Re:- Planning Application 3/2023/0165

Development	BILLINGTON		
Location	NEDDY LANE		
Marketing Name	CALDER GRANGE		
Drawing Title	Hall Road Layout		
Drawing Number	4441 / Eng / 440-1	Revision	-
Drawn By	CLB	Scale @ A1	1:500
Checked by	-	First Issue	09.02.23

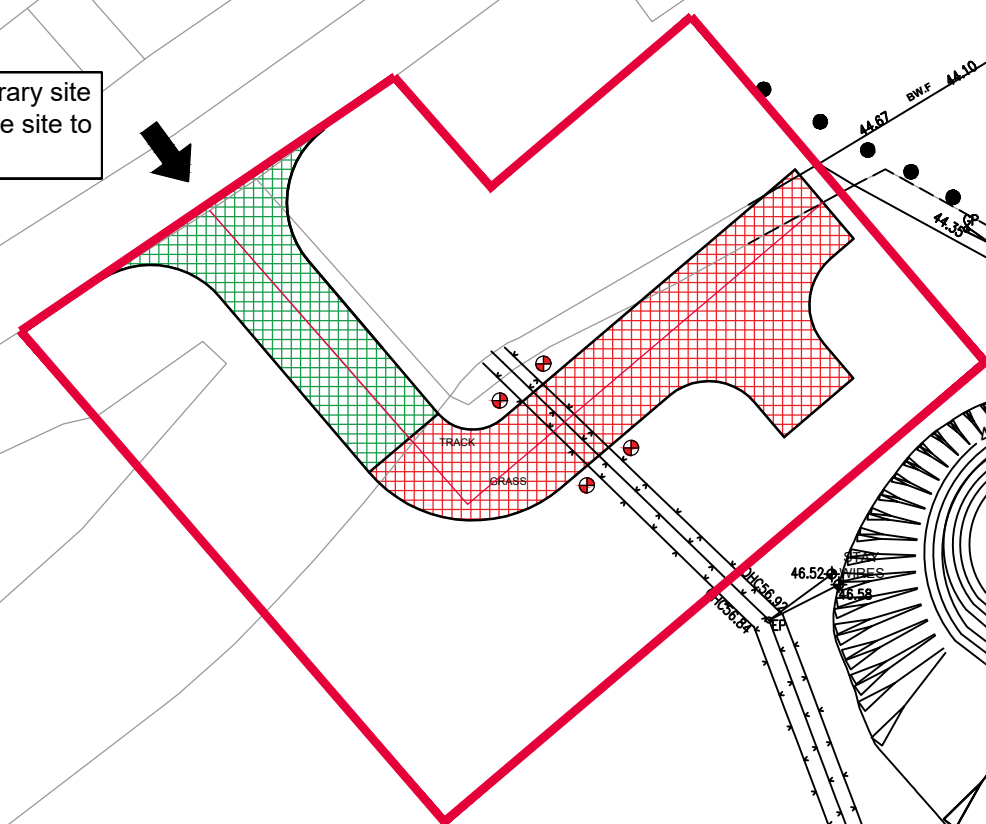
I strongly object to the above application, because it might result in accidents on the A59 due to fast through traffic inadvertently running into unexpected slow left-turning lorries. At the moment, there are no junctions off the A59 between the two adjacent roundabouts giving a clear stretch of road for around 2 miles.

It is the case that an attenuation pond needs to be built to avoid flooding of the Neddy Lane development, but the pond is only 20m. x about 5m., so surely does not need a new temporary road to remove the small volume of spoil. With a little bit of foresight, the developers could surely move the spoil within the site and up Dale View.
